PAGHAM PARISH COUNCIL

11th December 2019

Re: P/70/19/RES - reserved matters application associated with Outline Planning Permission P/58/15/OUT
Summer Lane Pagham

Further to the alterations made to the above-numbered application, Pagham Parish Council would like to submit the following comments:

Draft Site Plan

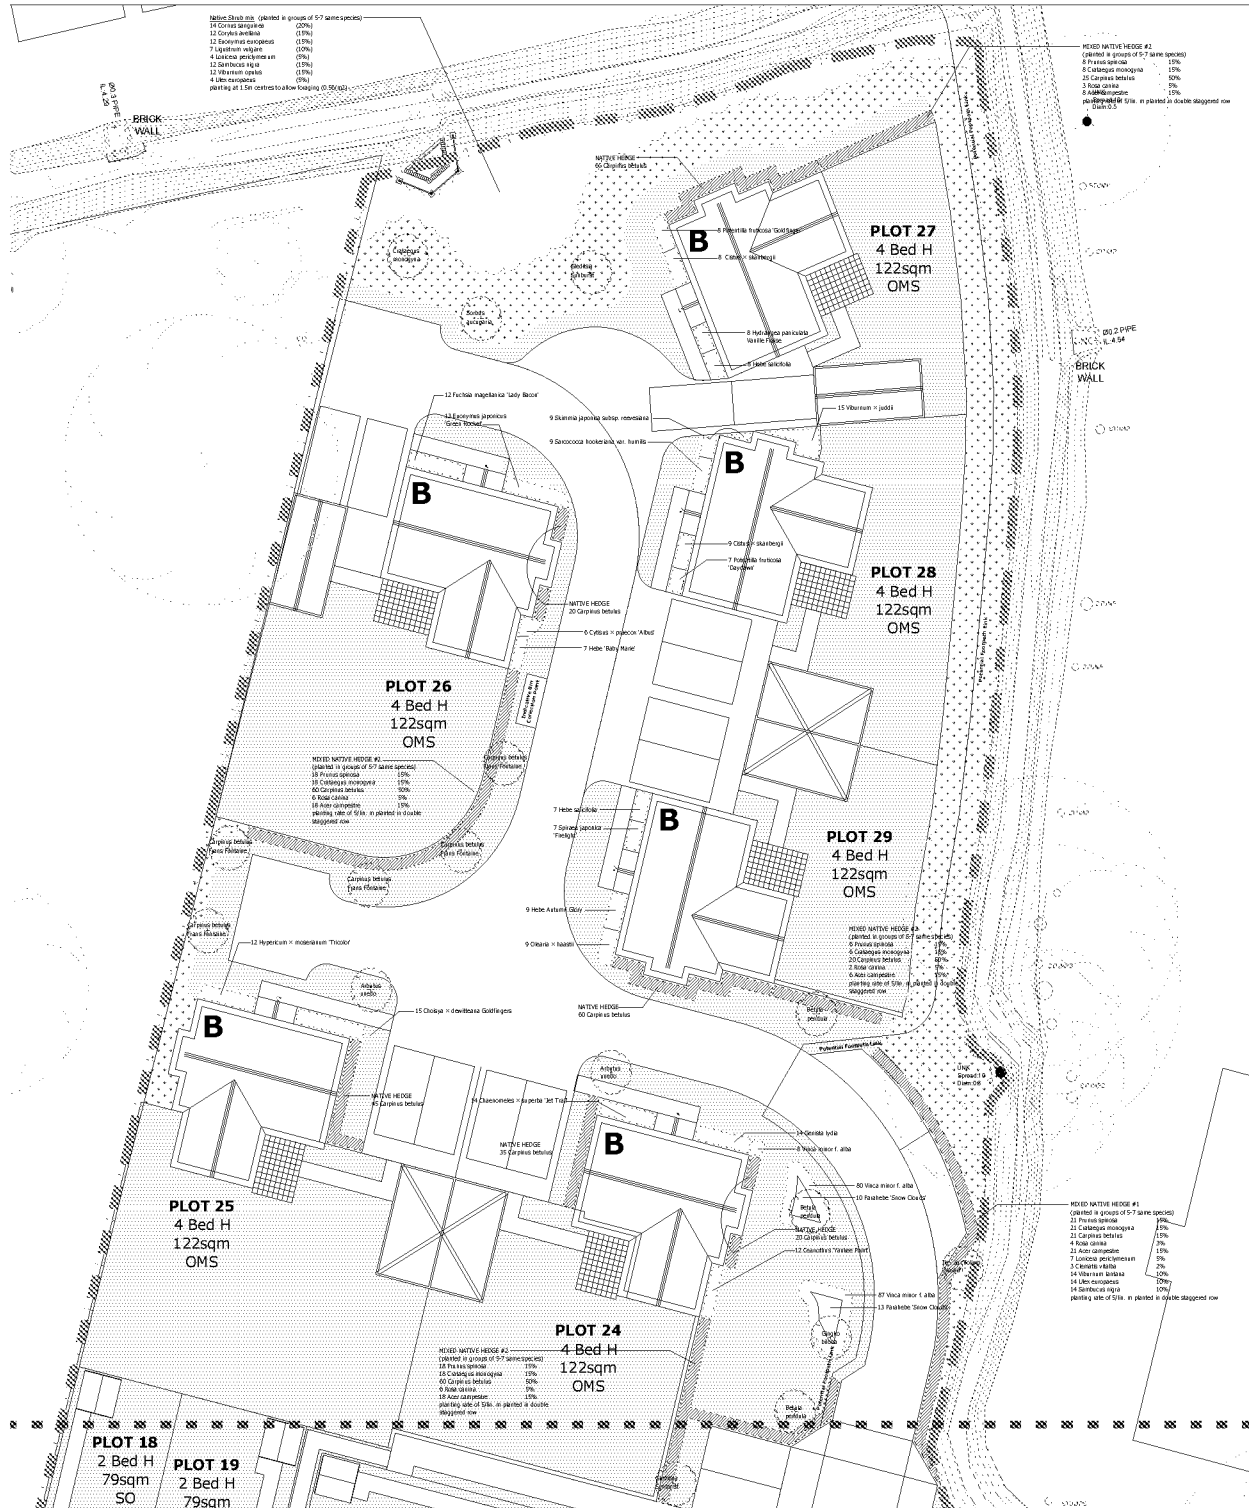
The Parish Council is pleased to see the improvements to the layout of the of the Public Open Space which is it proposed will ultimately be transferred to its ownership. Regarding the potential future link from the Village Hall paddock, we would like to see this access included in the design. There is a permanent pedestrian access through the car park which is not dependent on the Village Hall being in use. It would not make sense for there to be no access from our current play area/paddock and the new Public Open Space.

It had been suggested that there was no need for a LEAP on the Public Open Space as there is an existing play area at the Pagham Village Hall. However, there is still a LEAP shown on the revised plan. This would seem to be unnecessary. There is a permanent pedestrian access to the Village Hall play area and it is most likely that users from the development would access our facility on foot. If it is to be included, and therefore become the responsibility of the Parish Council, it would like to be consulted on the design and content of the facility.

The Council welcomes the improvement in layout of the development in relation to a potential connection to the neighbouring site and in respect of the increased space between neighbouring dwellings.

In relation to bin storage, the Council would like to see planting or other screening to help reduce the visibility of bins.
